ENG-CDR21014-R2-CDs.pdf Markup Summary

**C4.0**  
 Sheet 6 of 21

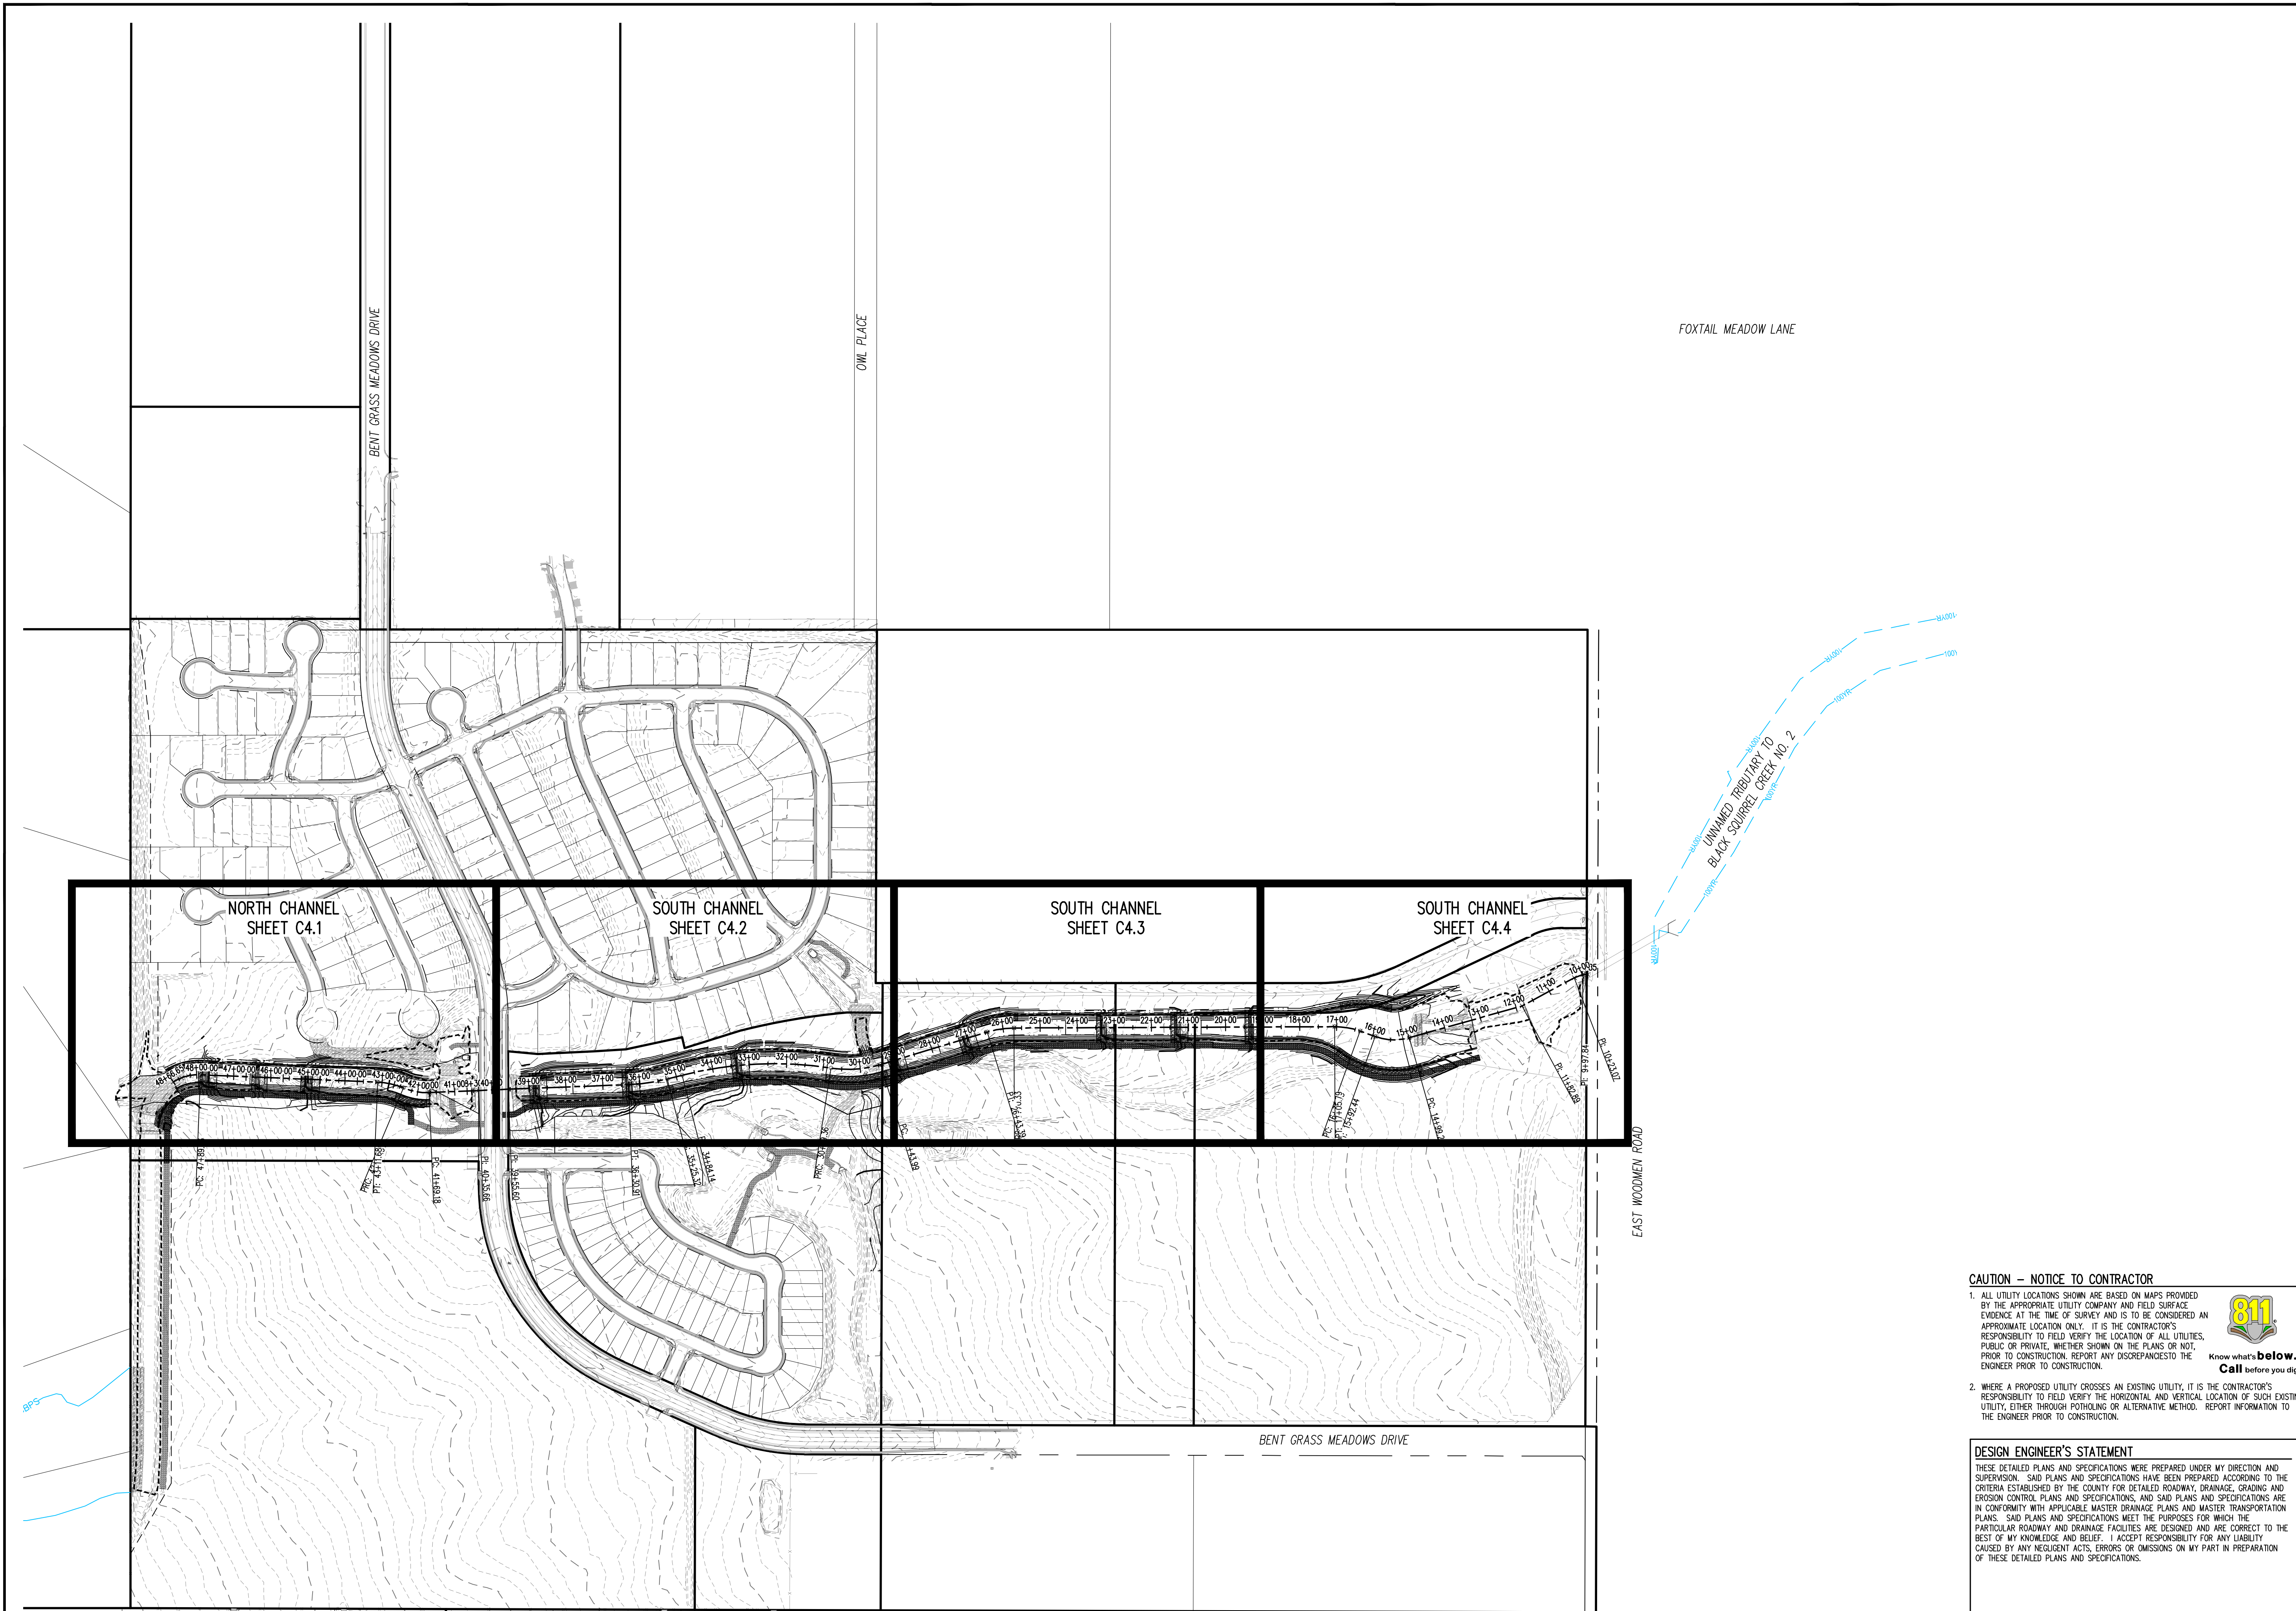
Show the low-flow channel (all sheets)

Label existing drop structure

Provide the HEC-RAS stations also

Show and label the sheet pile or concrete cutoff wall

label depth and freeboard (all sheets)

① DROP STRUCTURE (#1, #3) - PLAN VIEW  
 SCALE: 1"=5'

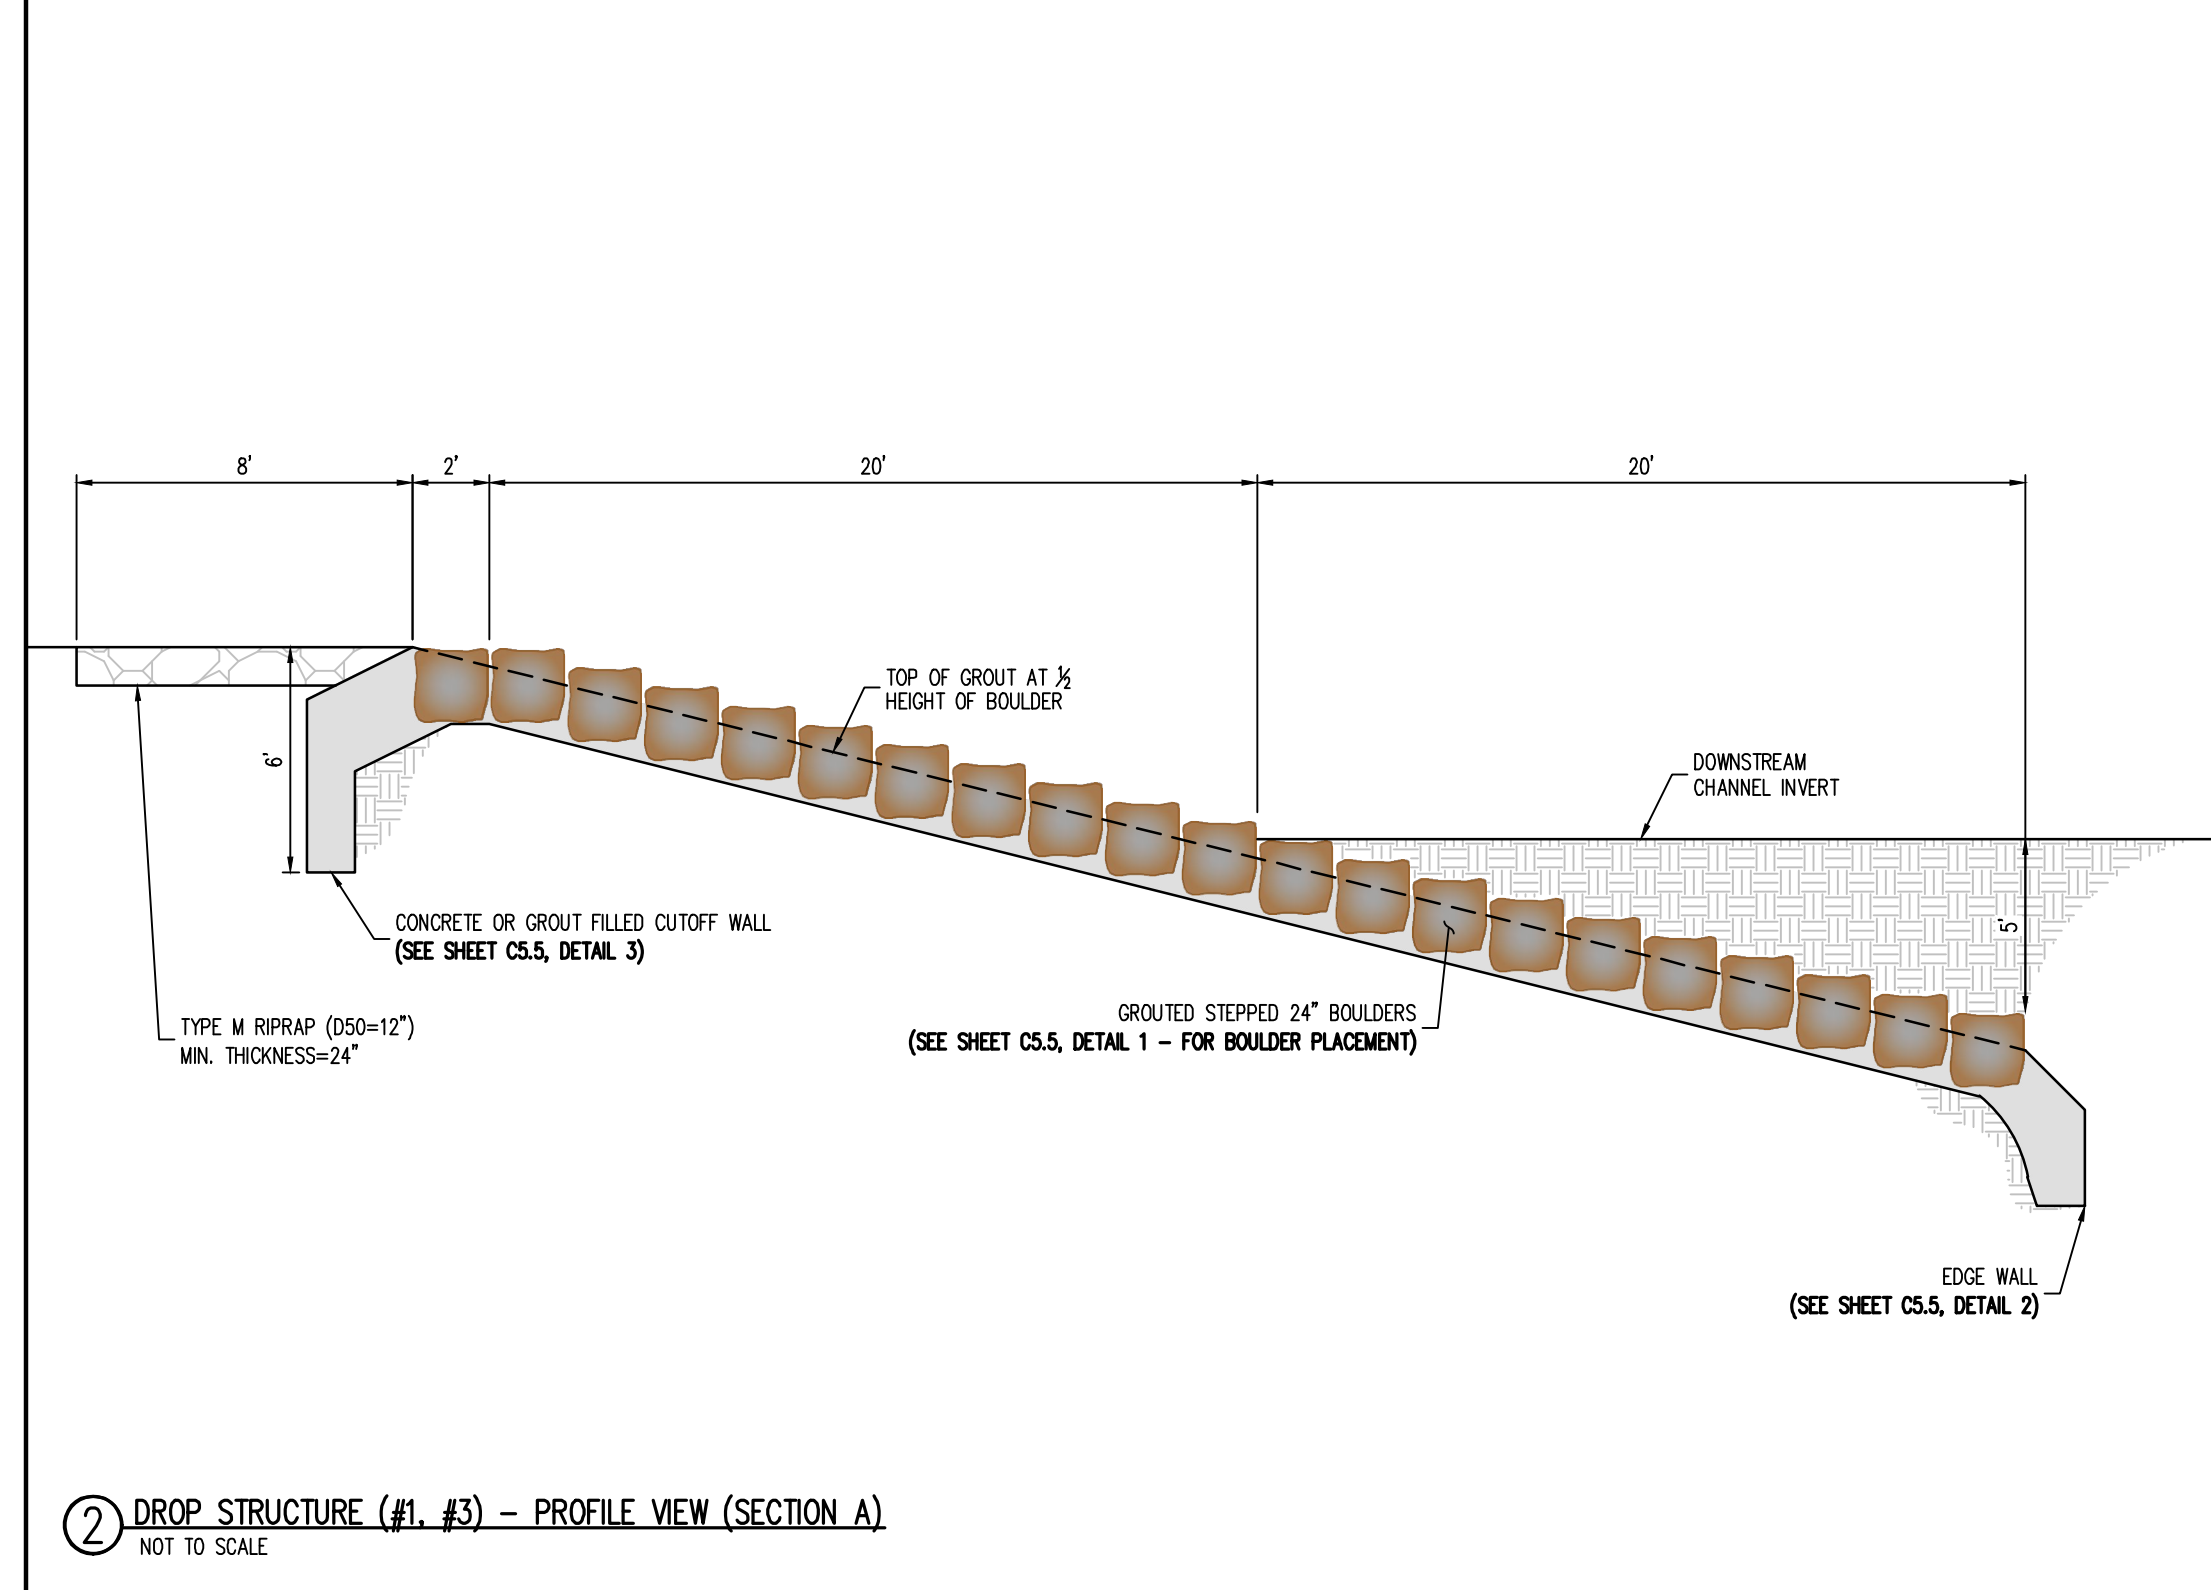
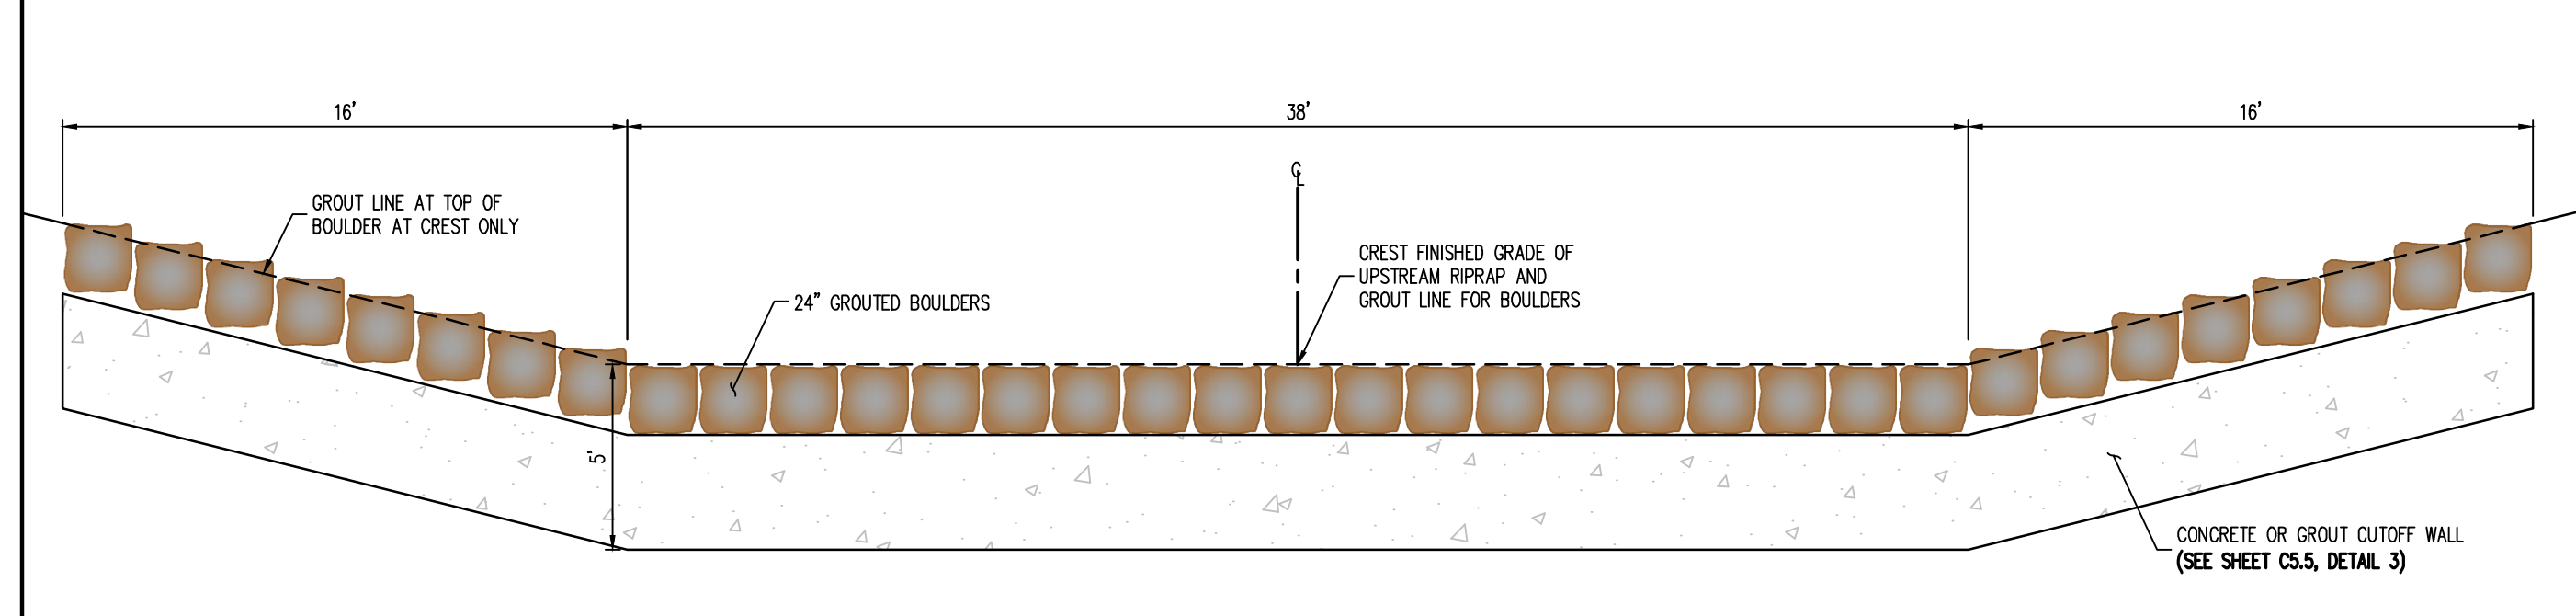
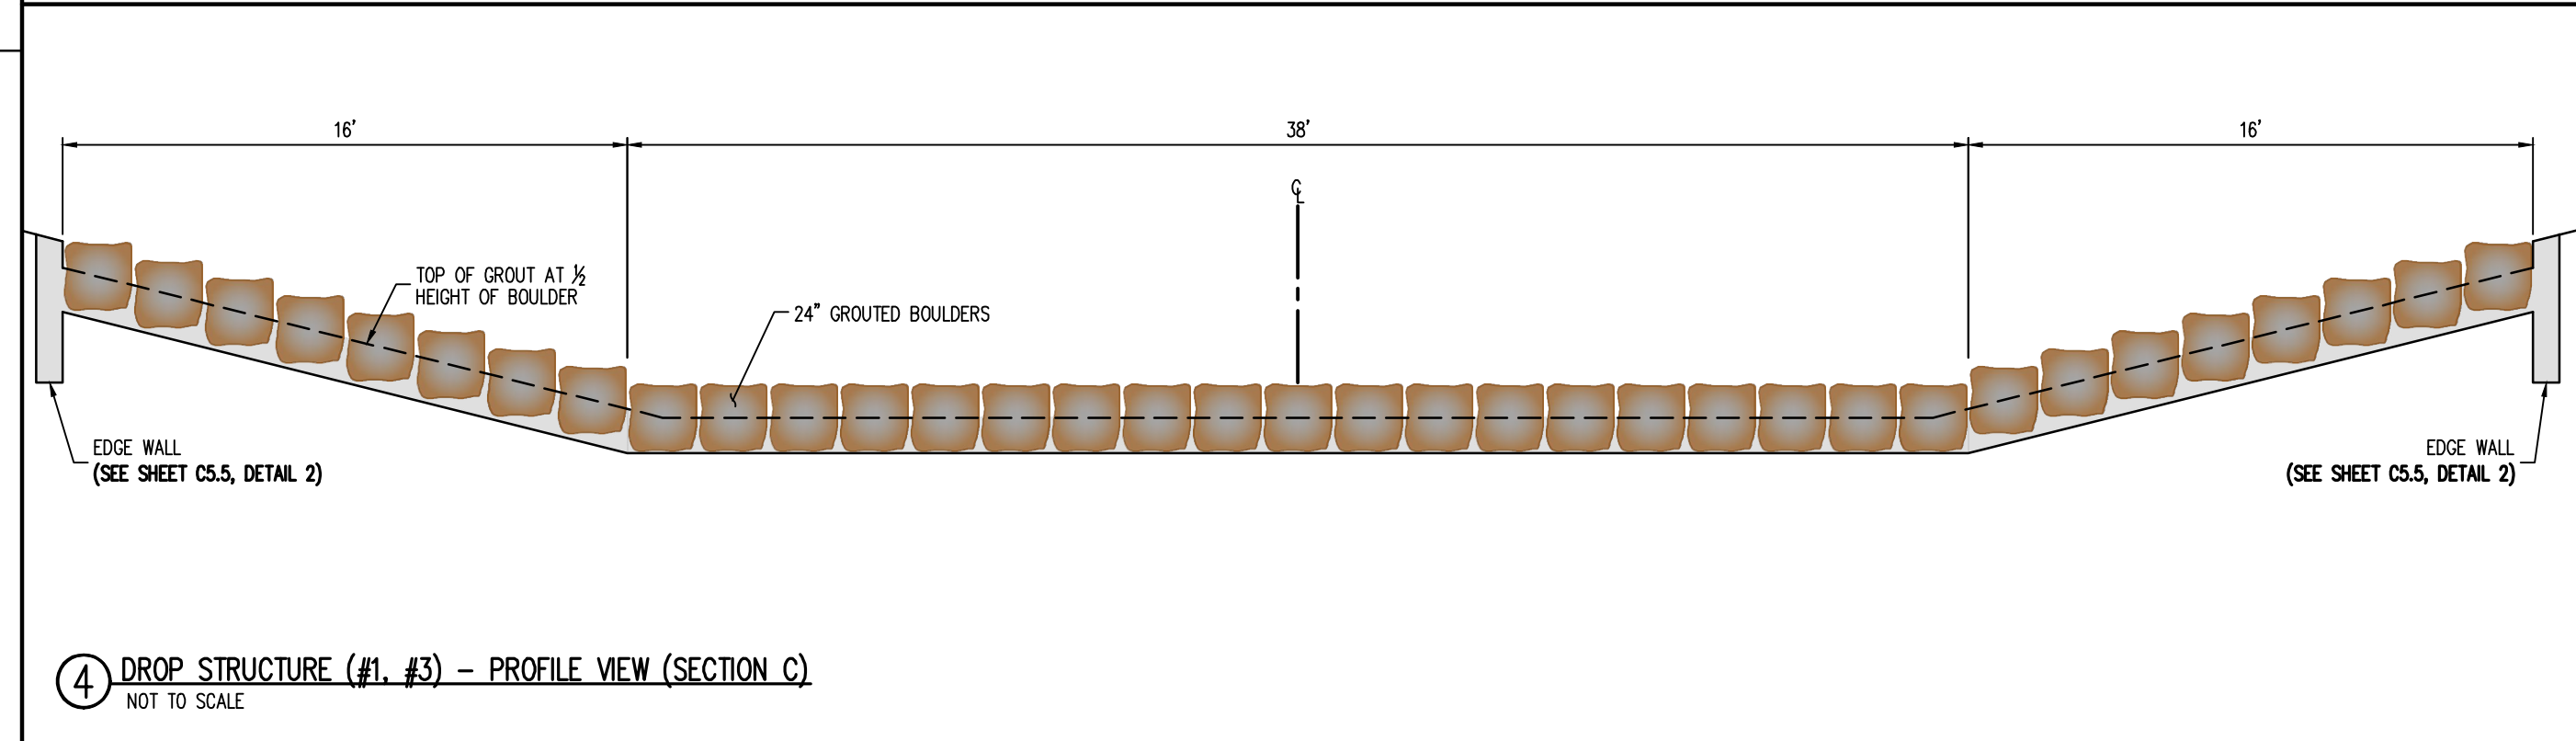
Label existing drop structures

Label existing drop structures
